Application Ref: EN020028

Application by Morgan Offshore Wind Limited and Morecambe Offshore Windfarm Limited (“the Applicants”) for an Order granting Development Consent for the proposed Morgan and Morecambe Offshore Wind Farms Transmission Assets (“the Proposed Development”)

The Secretary of State requires a response from the Defence Infrastructure Organisation (DIO) regarding birdstrike concerns and discussions in connection with questions 4, 7 and 9. These responses are detailed below; for ease the relevant question is replicated as a heading.

**Figure 1.6: Permanent mitigation area south of Newton-with Scales**

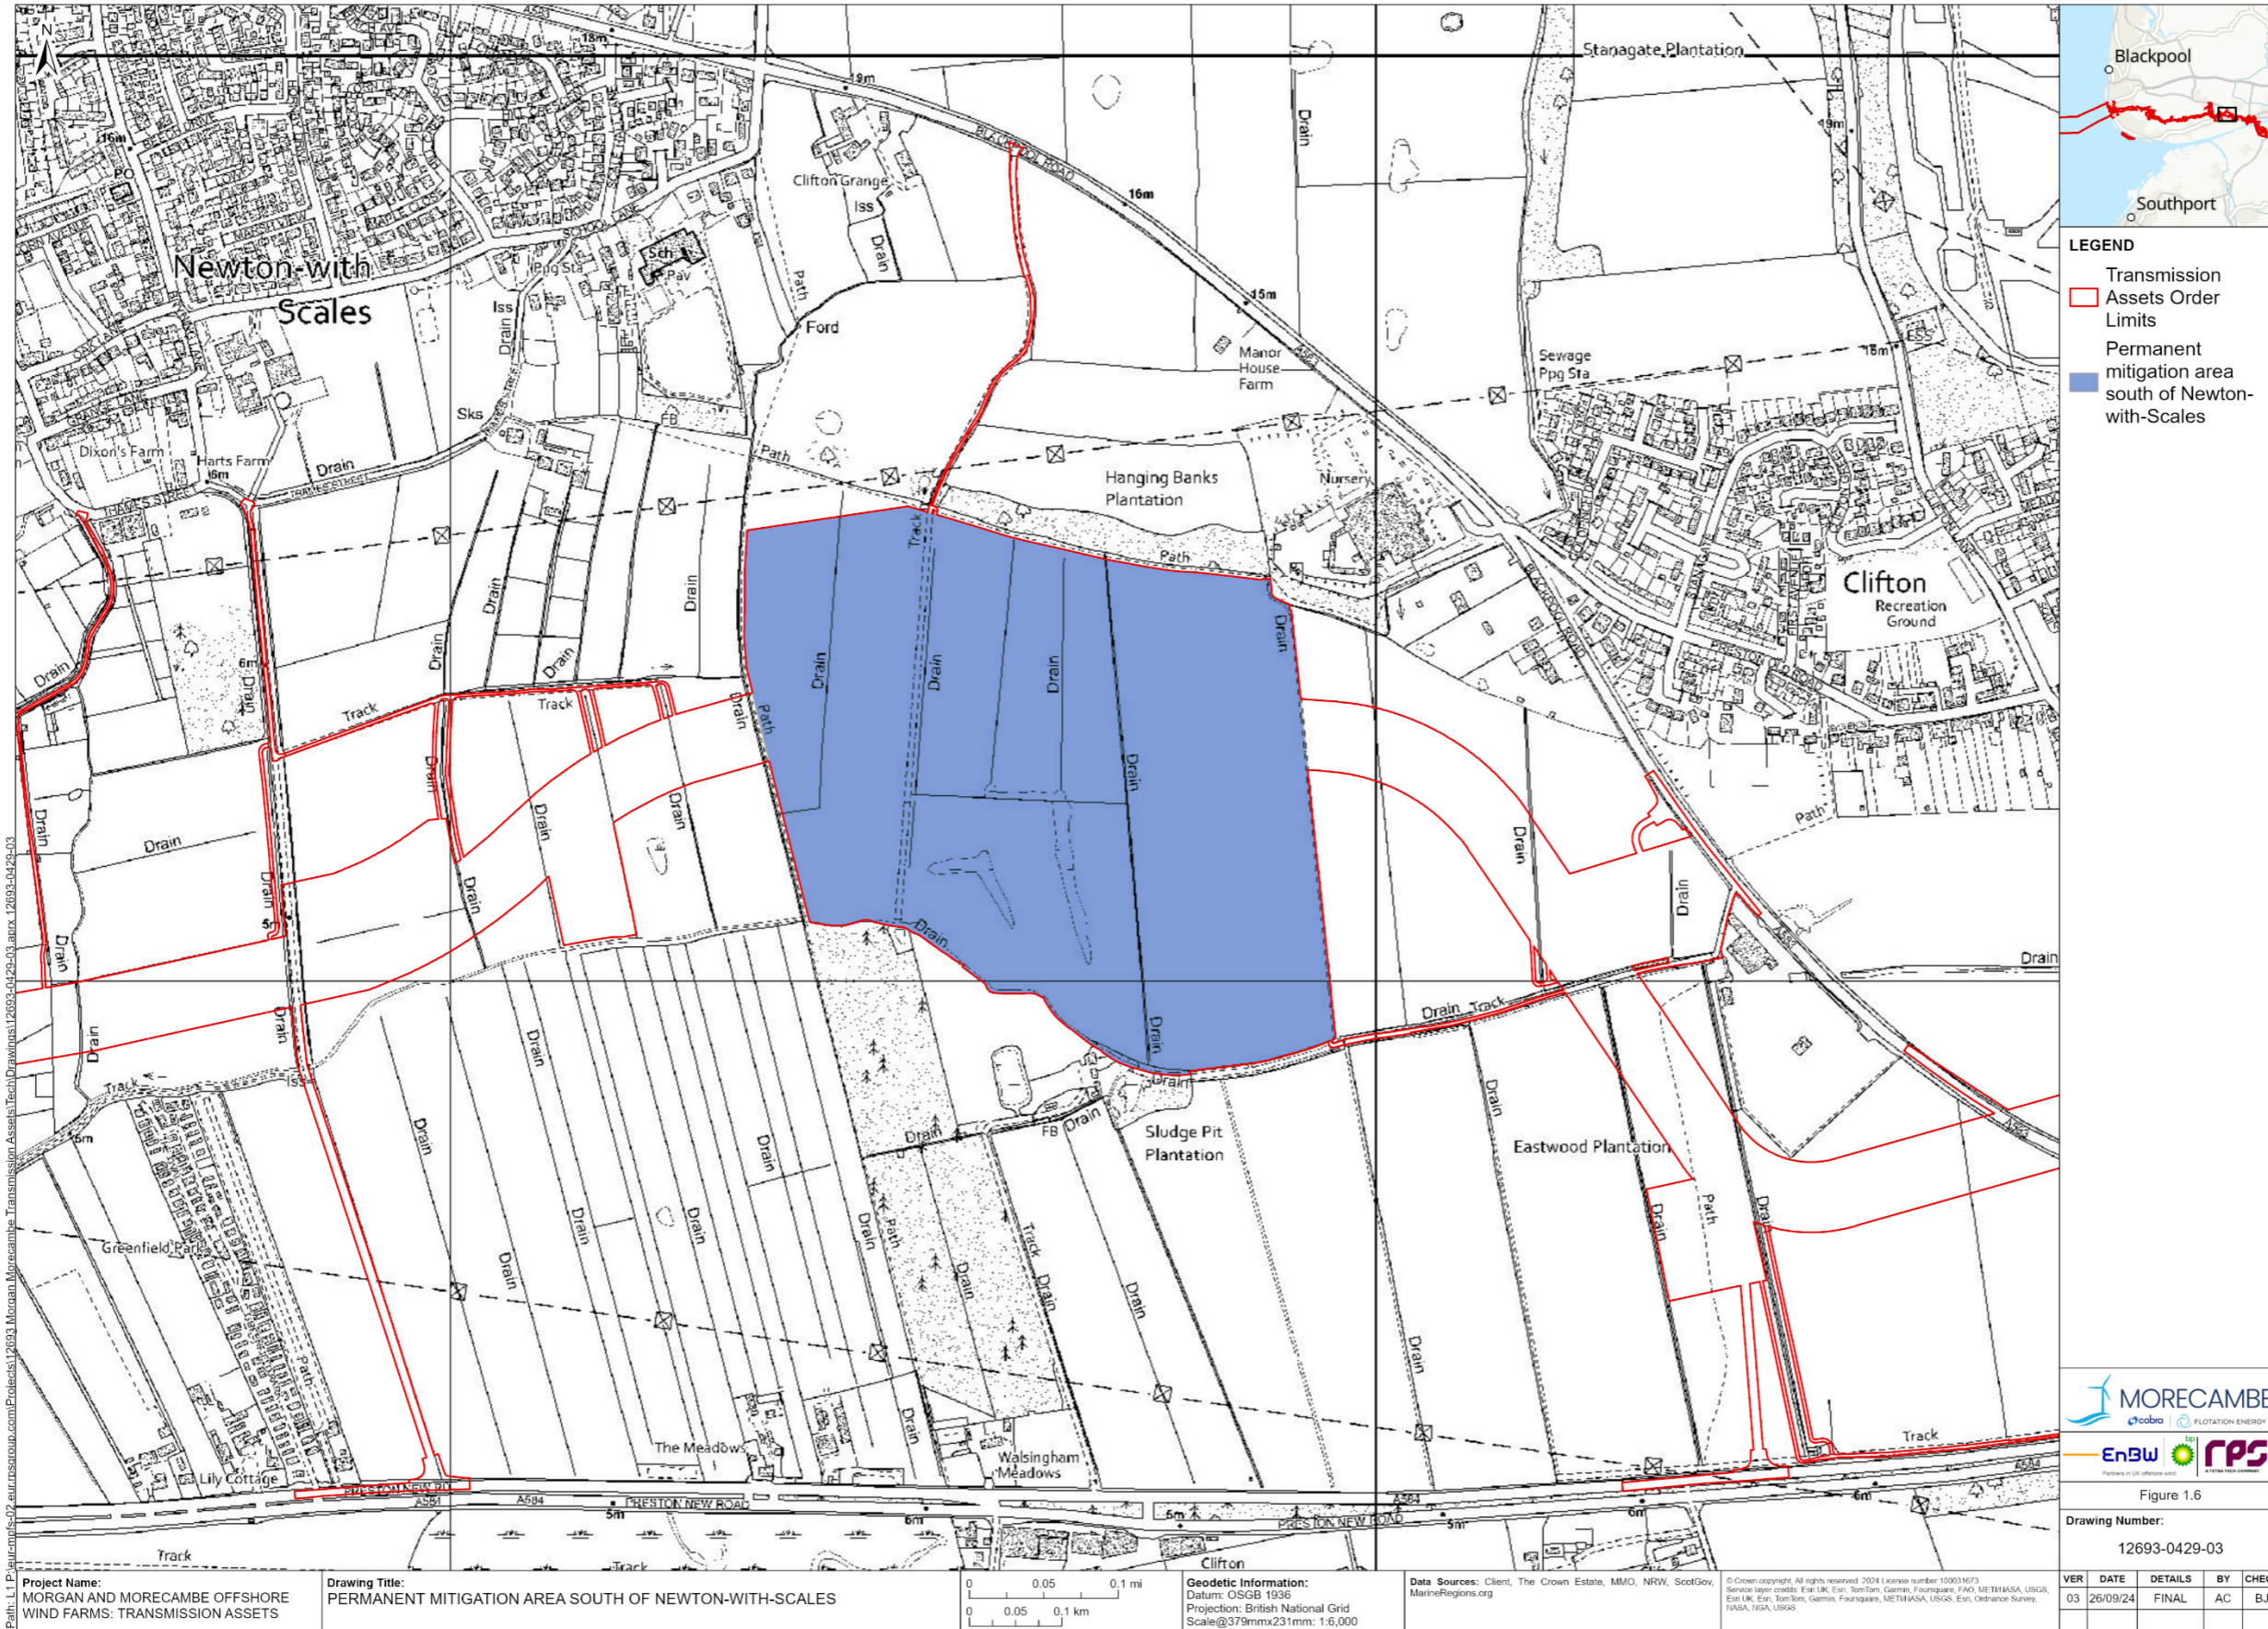
The MOD can confirm that the objection and concern responses provided relate primarily to the potential for the Newton-with-Scales site (Work nos. 49A/49B) to degrade aviation safety by increasing birdstrike risk. This is due to the proximity and location of the Newton-with-Scales site relative to the aerodrome, in particular the runway, its extended centreline and therefore the airspace in which aircraft are approaching or departing that runway, and to existing environments which support or routinely contain those large and/or flocking bird species hazardous to aviation safety. The introduction of an enhanced attractant environment at Newton-with-Scales is likely to both draw birds across the extended centreline of the runway and to provide an enhanced attractant/potential focal point close to airspace where aircraft are at critical stages of flight increasing the potential for birdstrike.

Whilst the submitted oWHMP is, in principle and subject to the acceptability of any Wildlife Hazard Plan submitted in accordance with requirements found at Schedule 2A, Requirement 27 and Schedule 2B, Requirement 27 in the draft Development Consent Order (Document reference: C1/F09, Rev: F09 22, dated October 2025), acceptable to address the potential harm caused by the temporary construction mitigation areas proposed at Lea Marsh (Works nos. 35A/35B and Works nos. 44A/44B) and Lytham Moss (Works nos. 35A/35B), it would not be considered acceptable to mitigate the potential harm caused by implementation of the permanent mitigation area south of Newton-with-Scales (Work nos. 49A/49B).

The MOD understand that the works proposed at the site south of Newton-with-Scales are intended specifically to enhance features of the site for the birds currently present, and to provide space for birds displaced at the substation sites. The result of these works is likely to be intensification of bird populations. Whilst at present these populations may be distributed across the wider area, the enhancement works proposed would be considered likely to provide a greater attractant to hazardous bird populations, effectively increasing the density of hazardous birds in this location.

The MOD would suggest that developing the Newton-with-Scales site to provide bird mitigation is problematic. In Table 1.4 of a previous draft oWHMP (Doc. Ref. S_D3/8/F03 dated 22 October 2026) the applicant has stated that with regard to the Newton-with-Scales site and the works designed for ducks and waders 'The intention of this mitigation is not to increase overall bird numbers in the area, but simply to enhance the area for the birds currently present and provide a safe space for birds displaced at the substation sites.' It is noted that the area referred to is not quantified. The more recent draft oWHMP (Document reference: S_D3_8/F04 dated 29 October 2025) omits this language and instead, at B2.2, refers to the potential for the Newton-with-Scales site to provide habitat for golden plover, to mitigate temporary impacts on teal and black-tailed godwit, and 'to benefit a far greater suite of terrestrial waders and wildfowl'. The MOD cannot accept any increase in the number of birds close to BAE Warton as such increases are highly likely to degrade aviation safety. By virtue of the location of Work nos. 49A/49B relative to BAE Warton, in particular the runway (closer to the extended centreline than either of the substation sites) and the approach and take off/climb airspace, and to those existing environments that provide habitats/attractive environments for those large and/or flocking bird species hazardous to aviation safety, those Works are likely to result in the movement of hazardous bird species through/across air space where aircraft are at critical stages of flight to the detriment of aviation safety.

The applicant has suggested that a management plan might provide a means to mitigate the harm created by the enhancement of the Newton-with-Scales site. The MOD do not consider it appropriate to seek to mitigate the intended effect of enhancing a habitat specifically to attract and support bird species by controlling the number of those bird species. The MOD does not think that a management plan is appropriate to mitigate the increased hazard to aviation safety introduced by the Newton-with-Scales proposals.

As set out in the Secretary of State's question, the MOD consider that, if the Secretary of State considers a management plan to be appropriate, a requirement must be set out that no number of hazardous birds above the levels currently present can be tolerated. The MOD suggest that this approach would directly contradict the purpose of habitat creation on the Newton-with-Scales site.
